A303 Sparkford to Ilchester Dualling Scheme TR010036

8.6 Statement of Common Ground with Somerset Drainage Board Consortium

STATEMENT OF COMMON GROUND

Regulation Number:	Regulation 5(2)(q)
Planning Inspectorate Scheme Reference	TR010036
Application Document Reference	8.6
Author:	A303 Sparkford to Ilchester Dualling Scheme Project Team, Highways England

Location

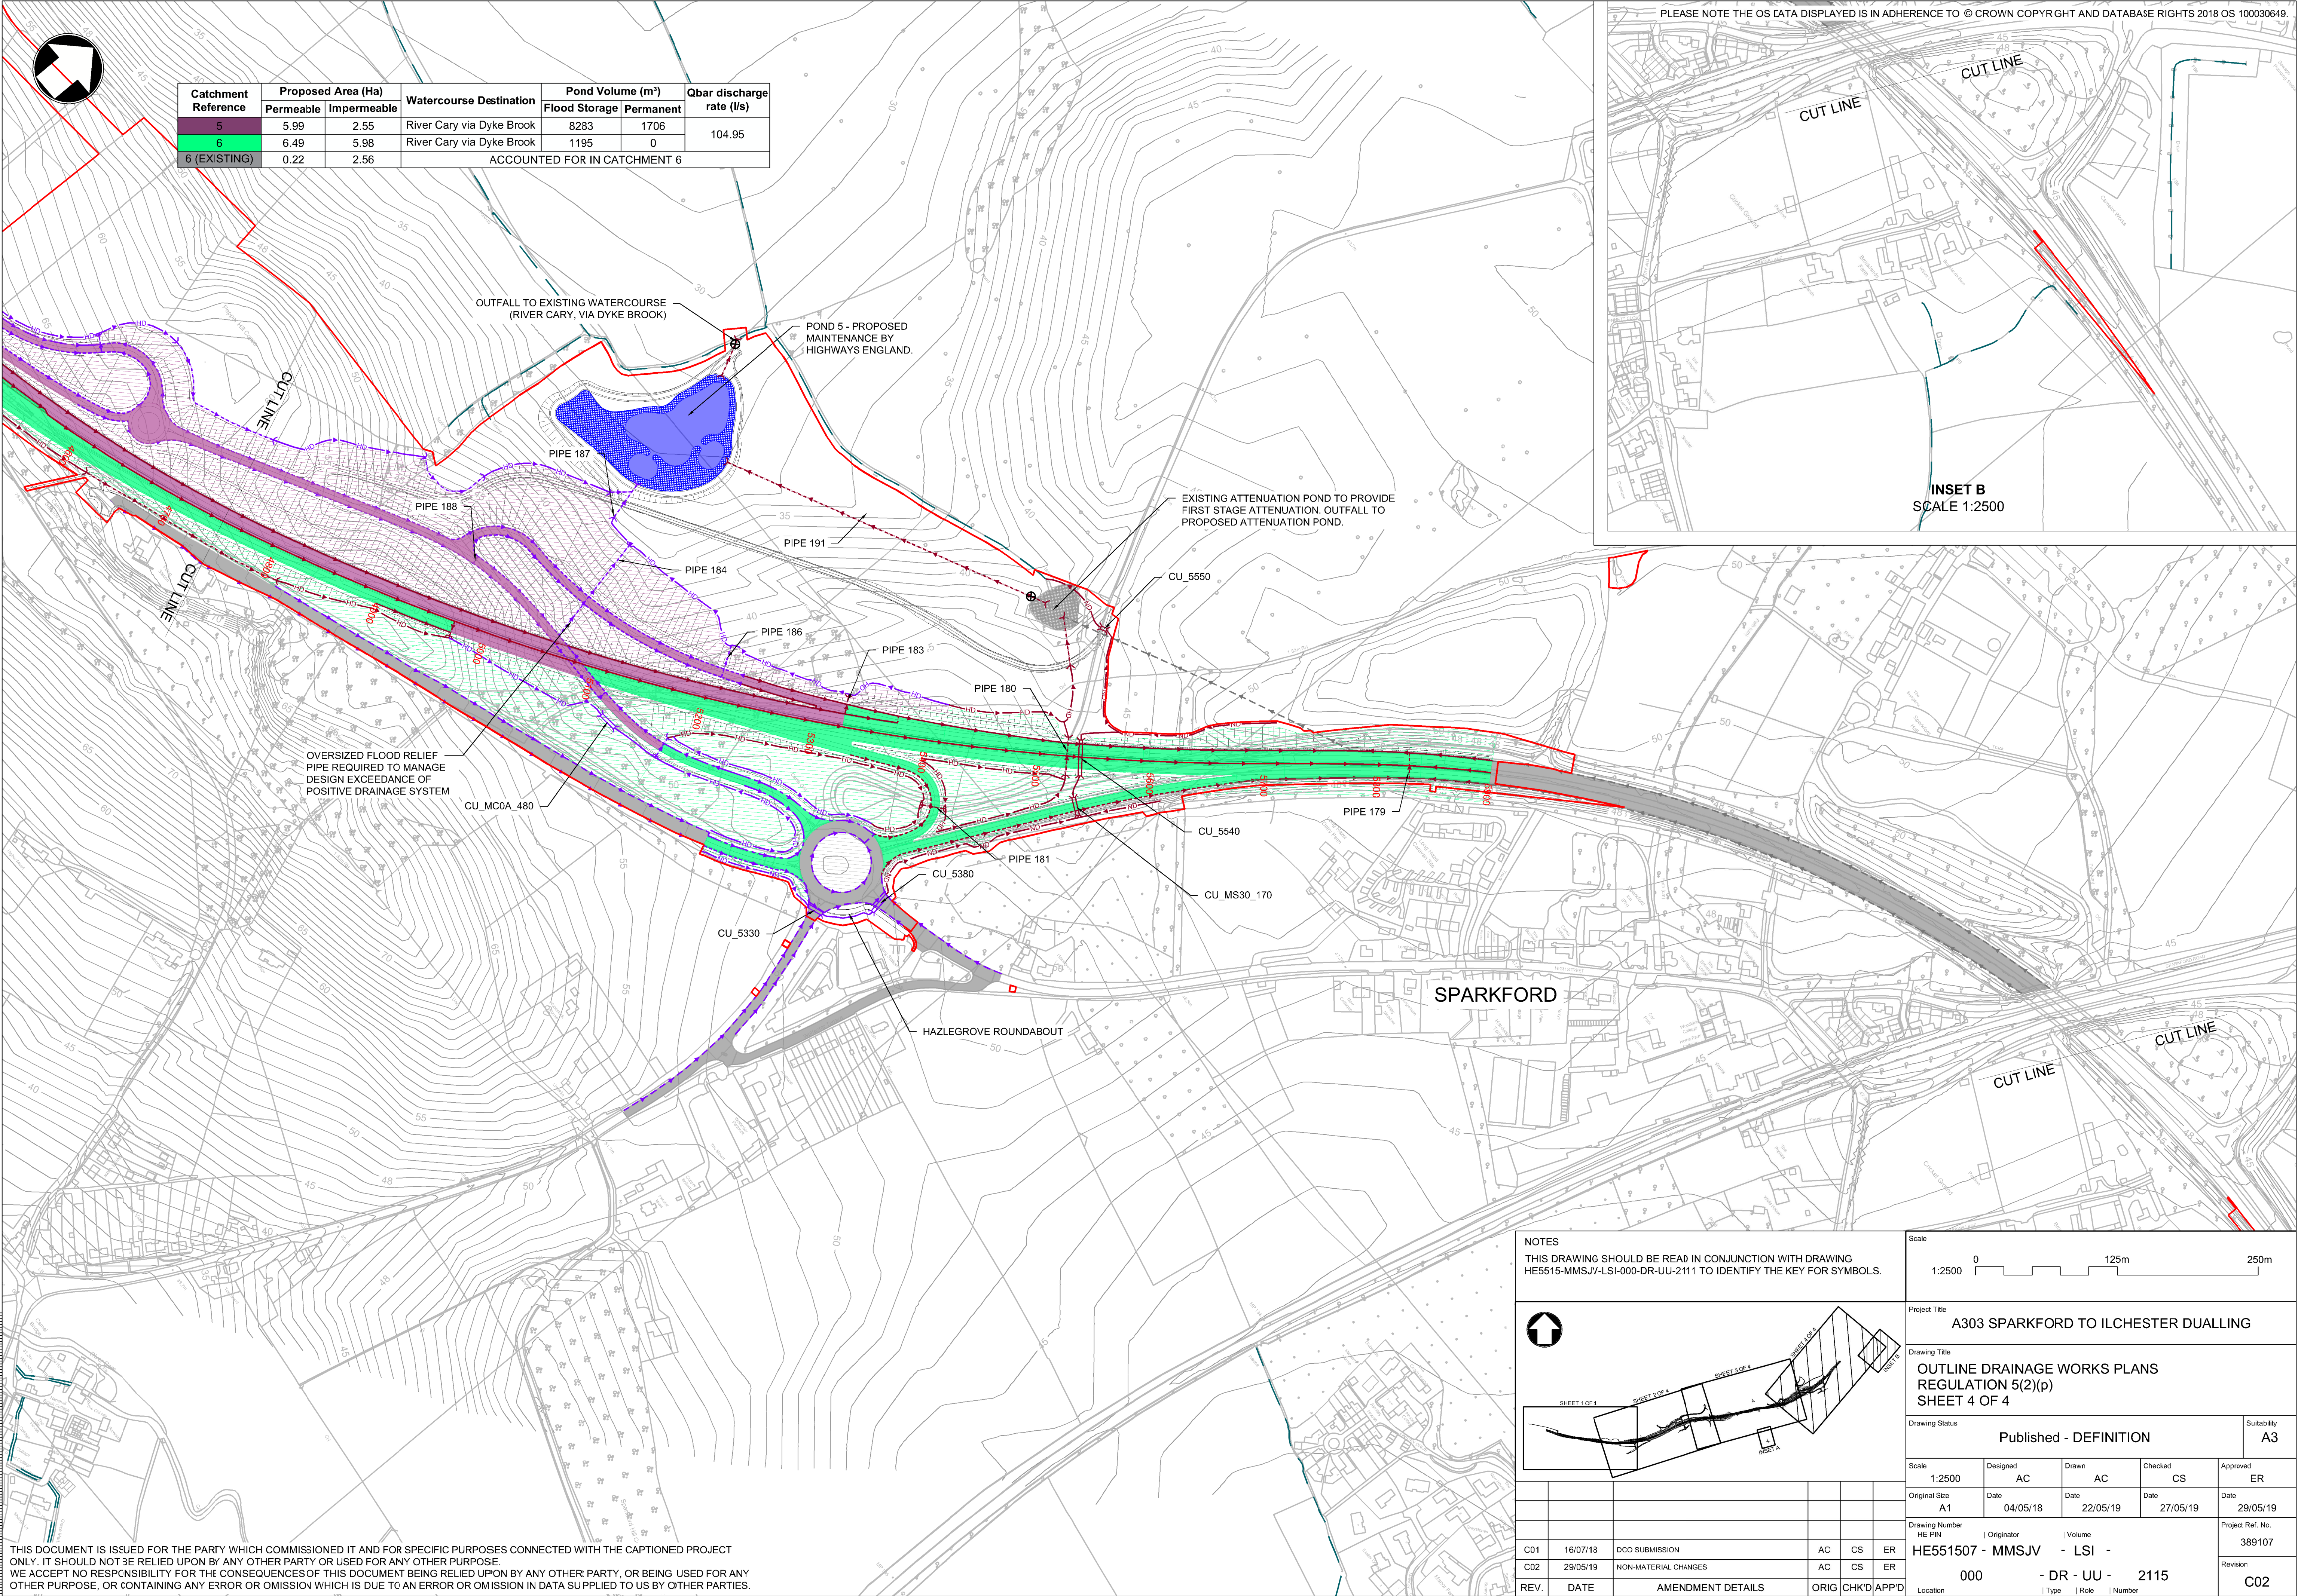
Topic	Stakeholder Comment	Highways England Response	Status
Water quantity	Confirmation is sought that the proposed design will control the overall volume, as well as the overall rate of runoff with sufficient attenuation provided.	Attenuation has been provided, with discharge limited to 1% annual exceedance probability (1 in 100-year event) plus 40% to account for the effects of climate change (Flood risk assessments: climate change allowances, Environment Agency), to no greater than the undeveloped rate of runoff, determined by the calculation of the mean annual peak rate of runoff for a greenfield site (Qbar). Preliminary design discharge rates and volumes shown in Outline Drainage Works Plans (document reference, TR010036/APP/2.11).	Agreed
Water quality	Confirmation is sought that the proposed pond design provides effective water quality treatment with the use of a permanent water level, and that this volume is sufficient in size. It is recommended that the SuDS Manual (C753) is referred to in the calculation of these permanent volumes, as well as the detailed design of the forebays and vegetation that will be essential for water treatment.	A permanent water level has been provided for each of the proposed ponds. The volume of treatment has been provided in accordance with the SuDS Manual (C753), i.e. '10-15mm of rainfall depth falling over the contributing catchment'. Accepted. Appropriate planting has been considered as part of the landscaping assessment and design. Attenuation feature discharge rates and volumes shown in Outline Drainage Works Plans (document reference, TR010036/APP/2.11).	Agreed

The use of grassed surface water channels is supported. Confirmation is sought to where	Grassed line channels have been incorporated where the carriageway is in cutting.	Agreed

There is concern that the maintenance tracks do not provide access to the control structures, which would need to be maintained and accessed in the event of a large pollution incident.	Accepted. The ponds and maintenance tracks have been redesigned to provide access to these structures. Access shown in Outline Drainage Works Plans (document reference, TR010036/APP/2.11).	Agreed
Existing watercourses and structures	There is concern for the condition of the existing watercourse that the existing A303 drains into, with known issues with some of the existing culverts. It is recommended that the condition and capacity of the flow route from the proposed outfalls are checked until the flow reaches a main river or watercourse, maintained by an	Accepted The proposed scheme utilises the existing outfall locations. Through implementation of the proposed drainage strategy the rate of discharge will be limited creating a betterment. It is noted that a condition survey has not yet been undertaken and this will be undertaken at subsequent design stages.	Agreed
